**WEST SUSSEX COUNTY COUNCIL
PLANNING SERVICES CONSULTATION**

SUBJECT: BE/63/17/OUT - Outline planning application with some matters reserved (Access only) for 20No. houses & flats, 1No. replacement dwelling (21No. units in total) with car parking, landscaping & associated infrastructure & access off Shripney Road (A29), following the demolition of the existing dwelling & outbuildings. This application is a Departure from the Development Plan.

The Cottage, Shripney Road, Bognor Regis, West Sussex, PO22 9PA

Bongor Regis ATC, A29 Shripney Road

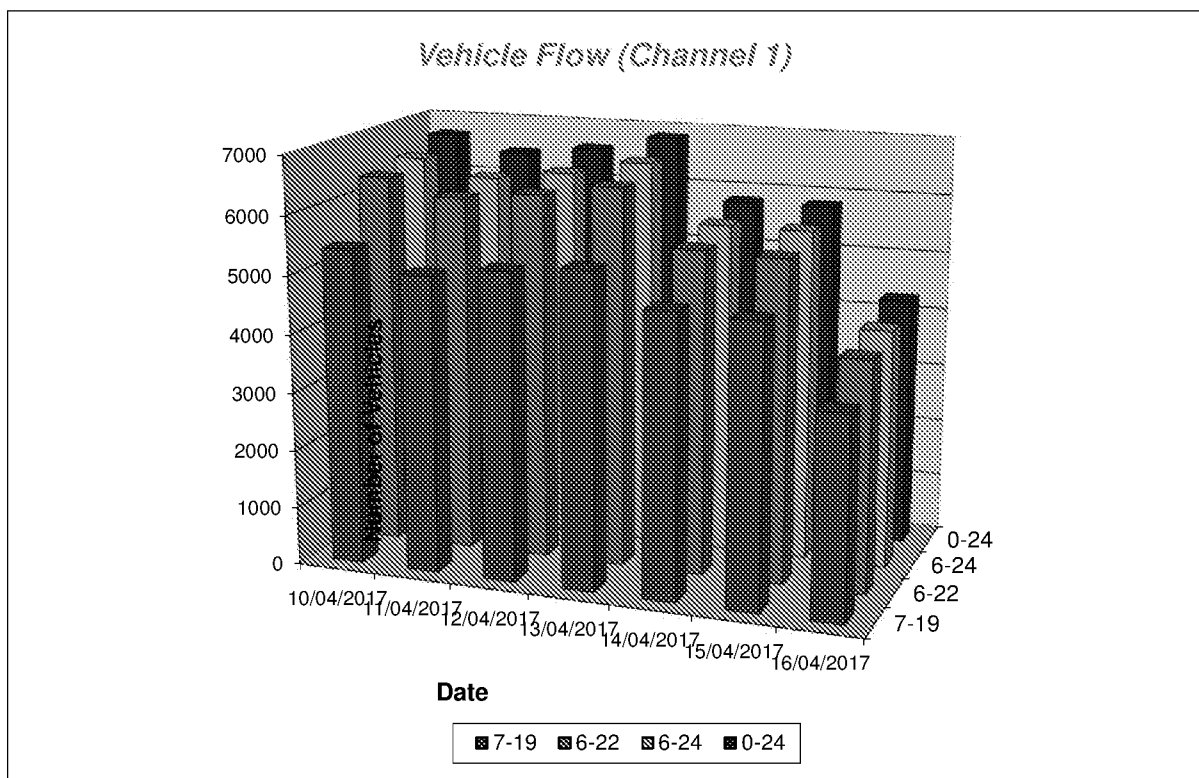
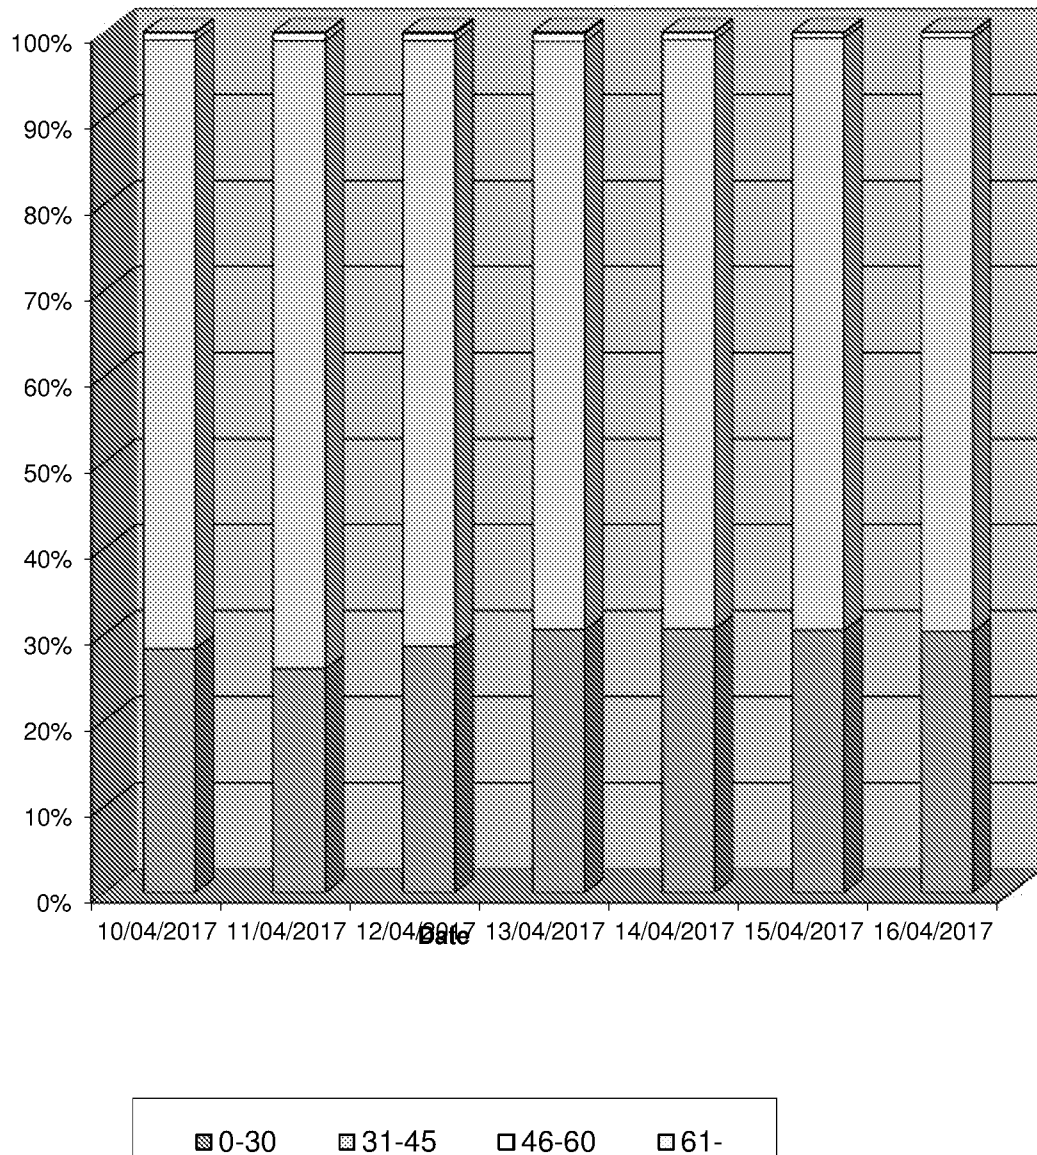
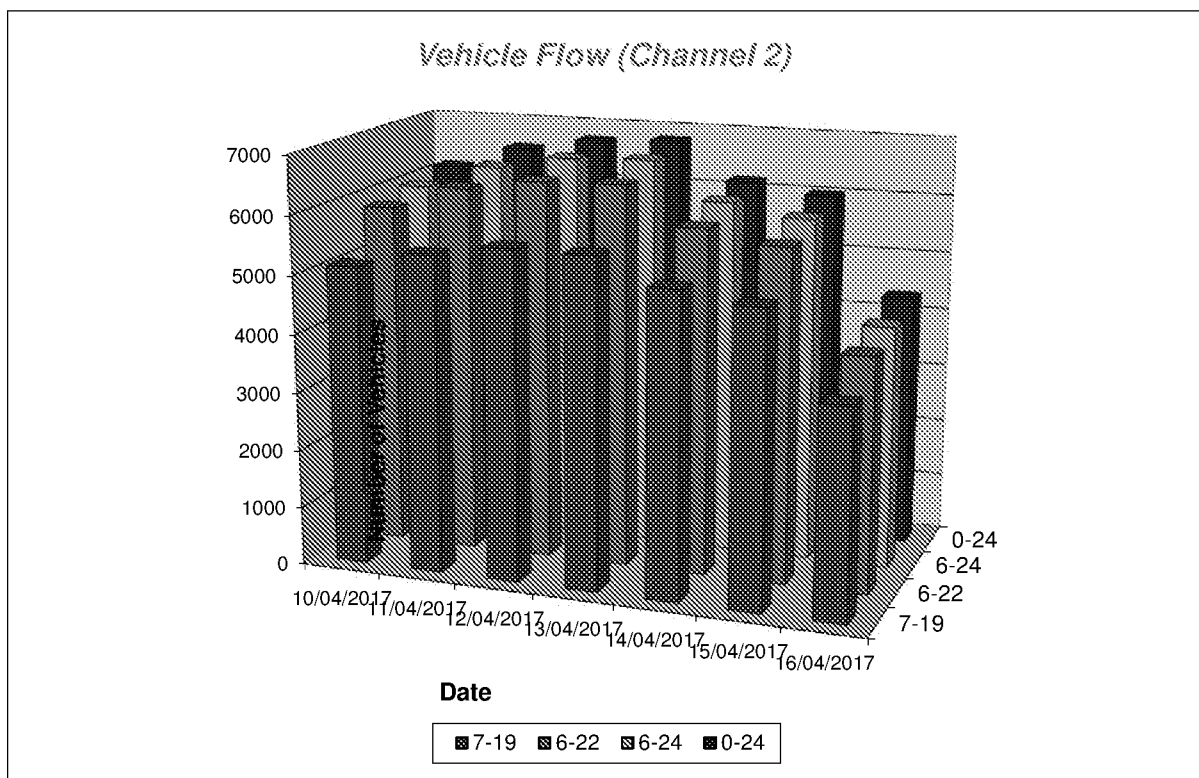
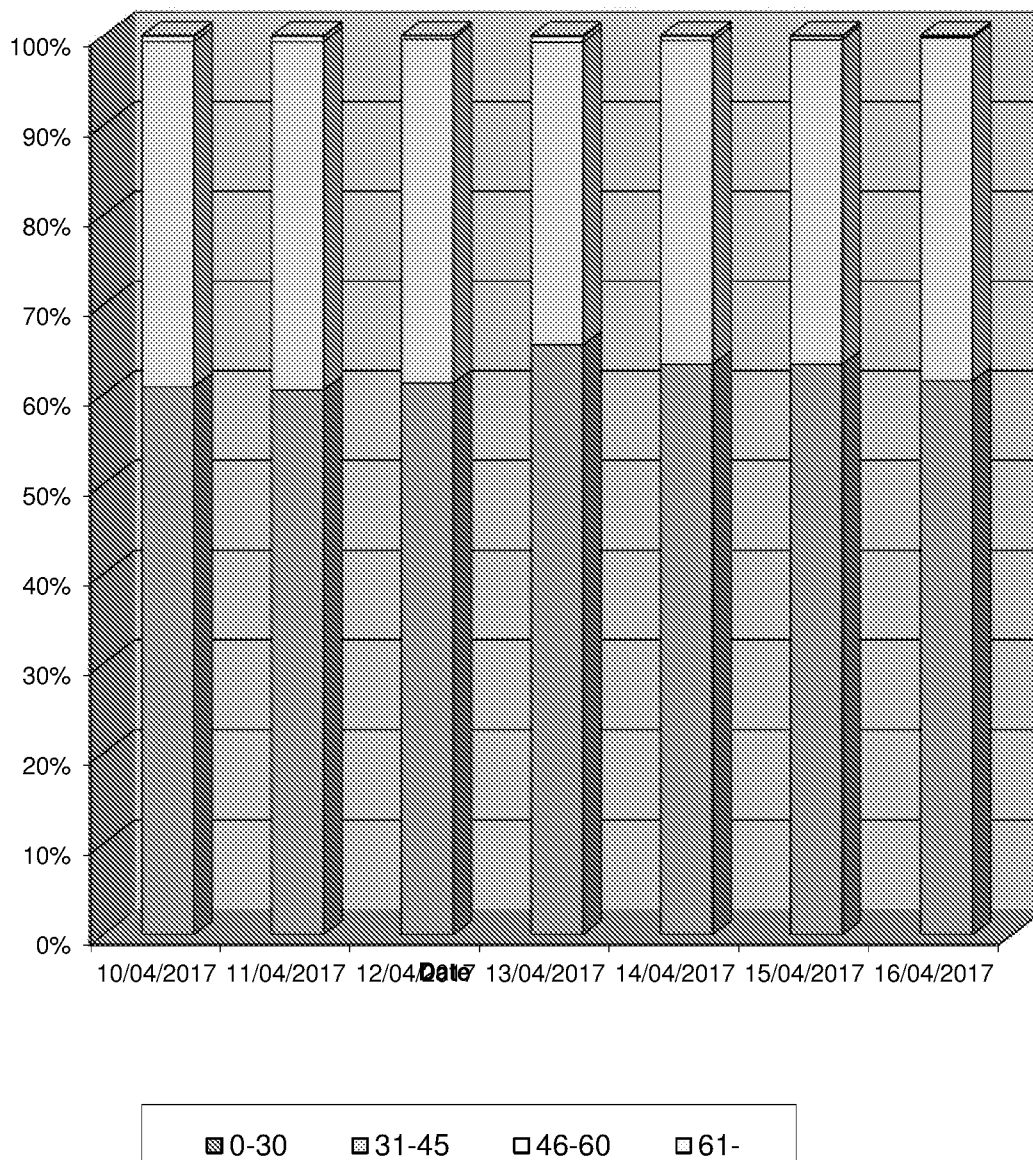
The Transport Statement (TS) states that an Automatic Traffic Count (ATC) was carried out. This was conducted in Easter Half term. This is not a traffic neutral time and therefore not acceptable in terms of capturing a true reflection of traffic volumes or speeds in the am/pm peak hours.

The submitted ATC results have been compared to those from a nearby WSCC fixed ATC located to the south of the site. Comparing this data, it is evident that there is a notable difference in the volumes of traffic. This is detailed in the table below.

Based on the above findings the LHA are not satisfied that the ATC supplied with the application offers a true reflection of traffic volumes/speeds. The ATC will need to be repeated.

Notwithstanding the above, the survey details 85th percentile speeds southbound of 34.5mph and 37.1 mph northbound. The TS goes on to conclude that given the speed survey data it is appropriate to apply Manual for Street's (MfS) parameters for the visibility splays to the south of the access given recorded speeds and road geometry. Visibility to the north is based upon the standards within the Design Manual for Roads and Bridges.

Visibility and Access Arrangements

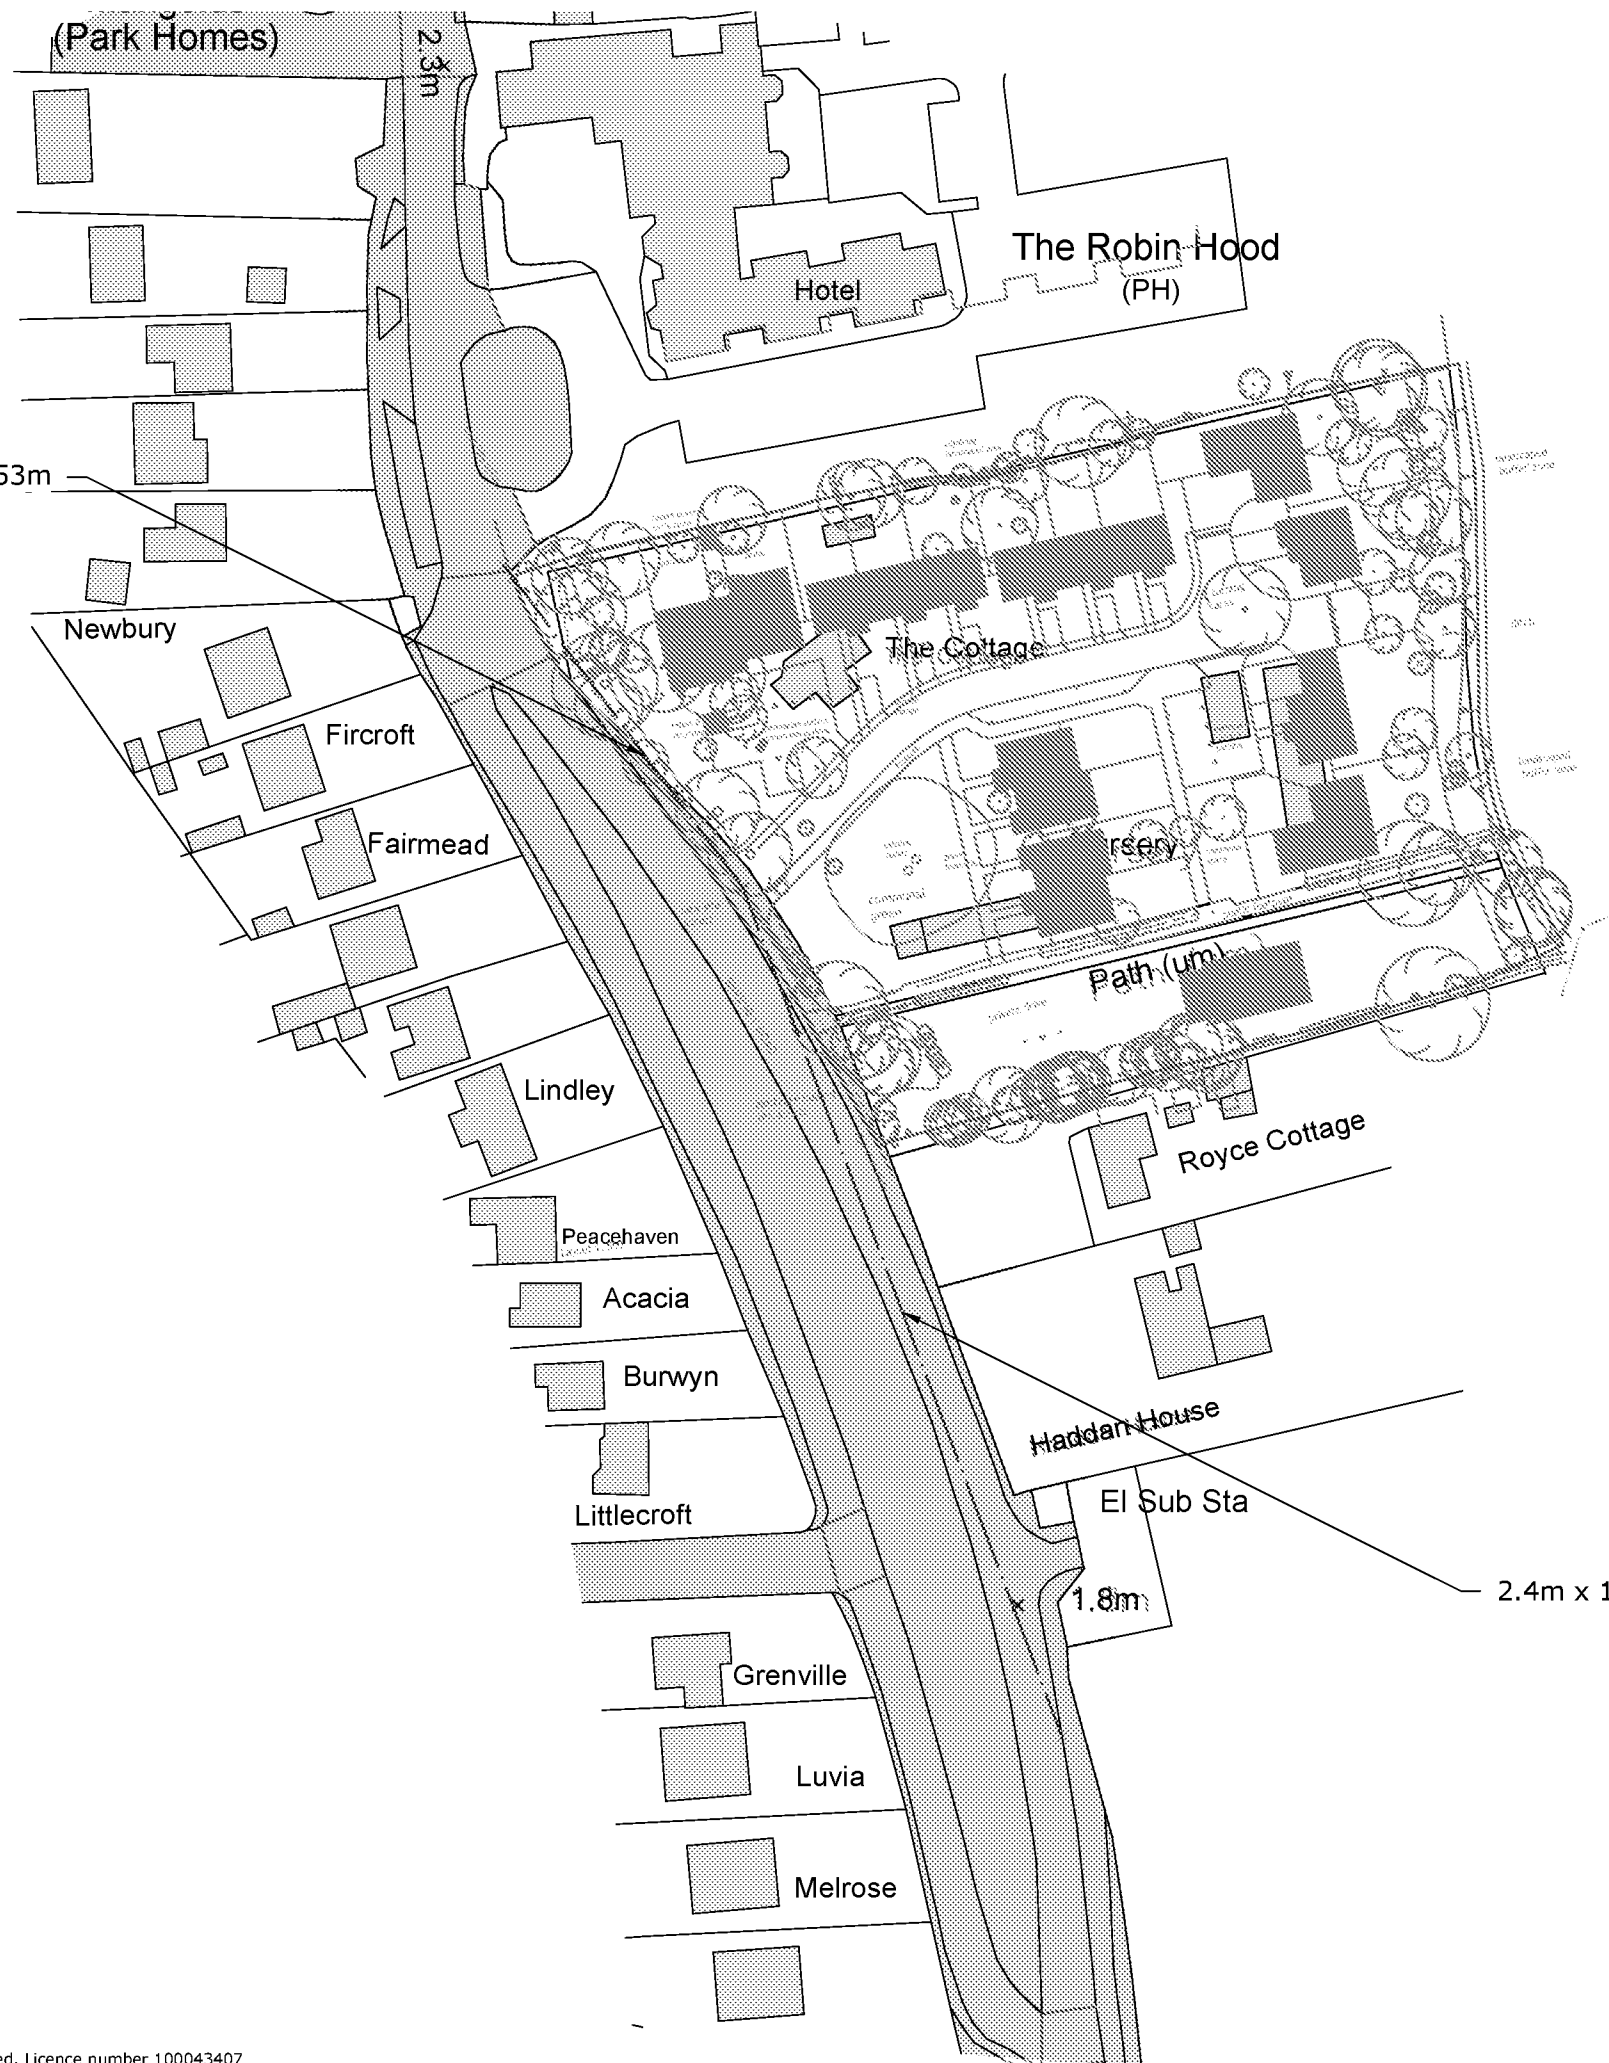
Visibility splays would need to be in accordance with TD9/93 for a 40mph zone (120m from a 2.4m set back). The LHA are not in support of MfS parameters being applied to an access onto the A29 where the posted limit is 40mph.

Visibility appears achievable to the north of the access to 120m but not to the south. 53m is shown on drawing no:334/P/03, which is well below DMRB standards. In the event that DMRB standards cannot be achieved, departures from standards can be considered by the LHA through the adopted WSCC departures process. The RSA has also highlighted visibility under problem 4.1, the audit team have said '*Ensure visibility to and from the crossing point and site access is suitable for the speeds and nature of the road*'.
